# Rezoning Transportation Analysis

Petition Number: #2022-183

Date	Description
03-23-23	First Review (PDM)
04-20-23	Second Review (PDM)

Rezoning Plan

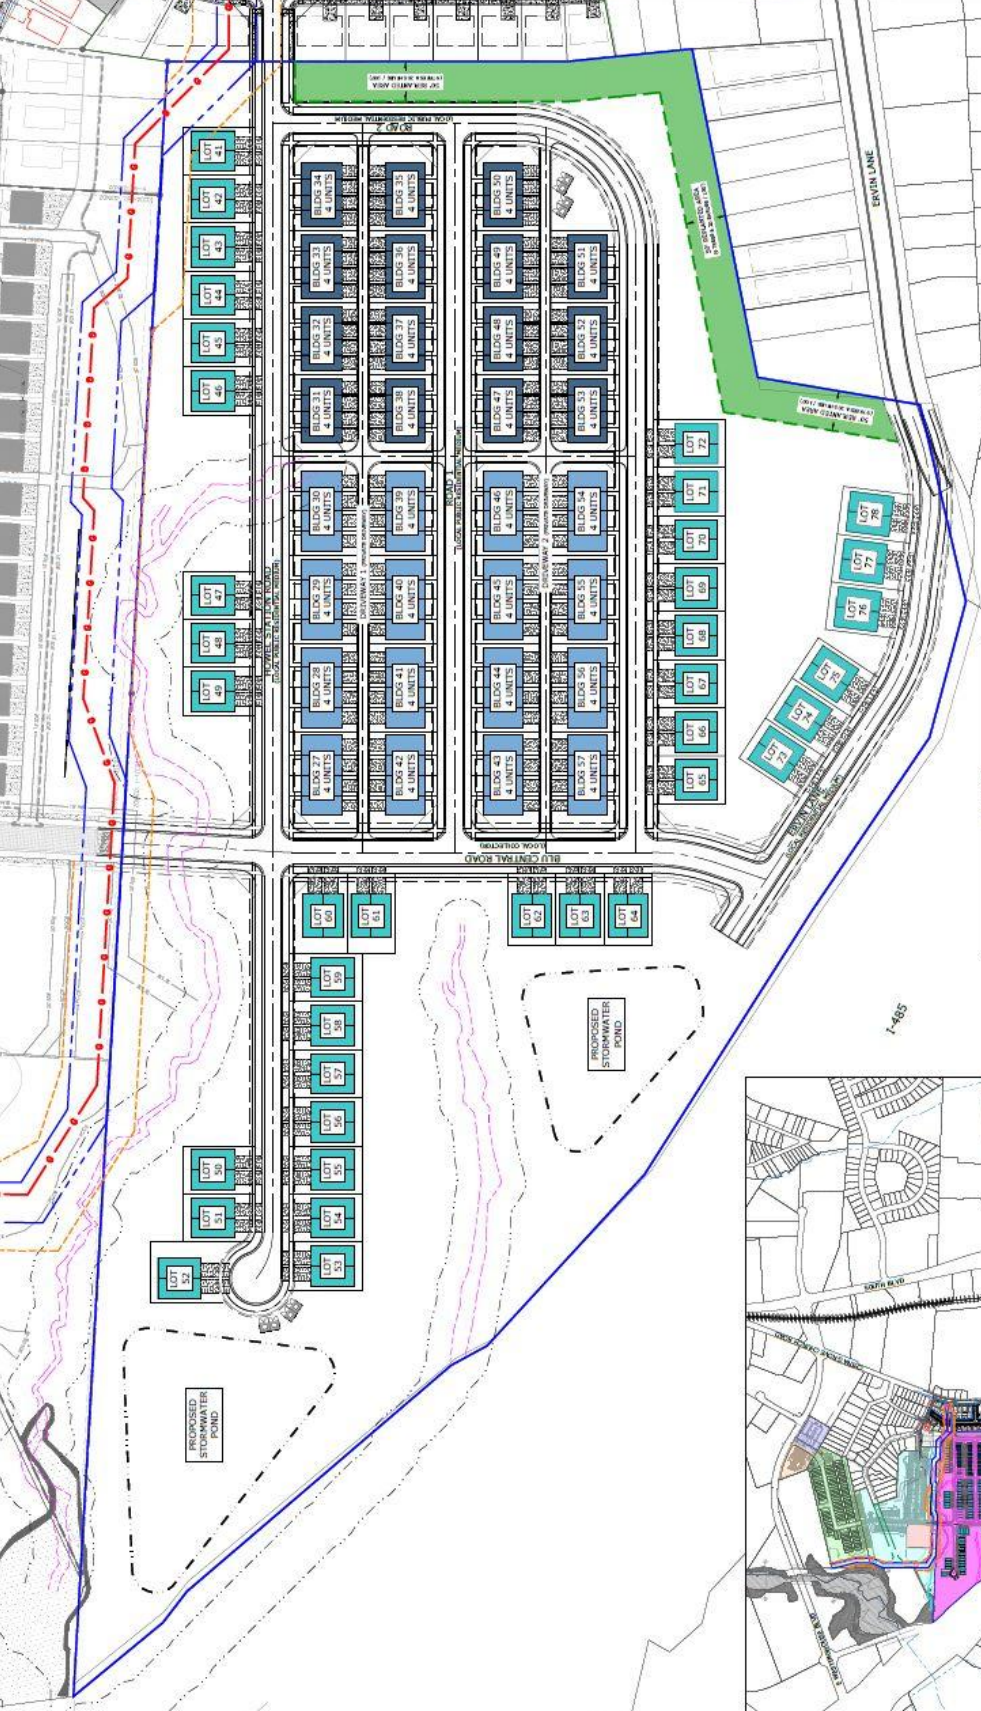
3. **Outstanding Comment from 03-23-23:** Revise site plan to clarify Ervin Lane and Blu Central Road as public roads.
4. **Outstanding Comment from 03-23-23:** Revise site plan to dimension all public rights-of-way from the public road centerlines.

5. **Outstanding Comment from 03-23-23:** Revise site plan and conditional note(s) to commit to construct an 8-foot planting strip, and 6-foot sidewalk on all public roads per Chapter 20. The site plan shall label and dimension both items from the back of curb and gutter or edge of pavement.

11. **New Comment from 4.20.2023 Revised Site Plan:** Revise site plan to provide a single continuous collector street (Blu Central Road) to Ervin Road. The collector street shall meet CDOT design standards.

12. **New Comment from 4.20.2023 Revised Site Plan:** Revise site plan to continue Ervin Lane as a street. A stub is not needed here based on the revised site plan.
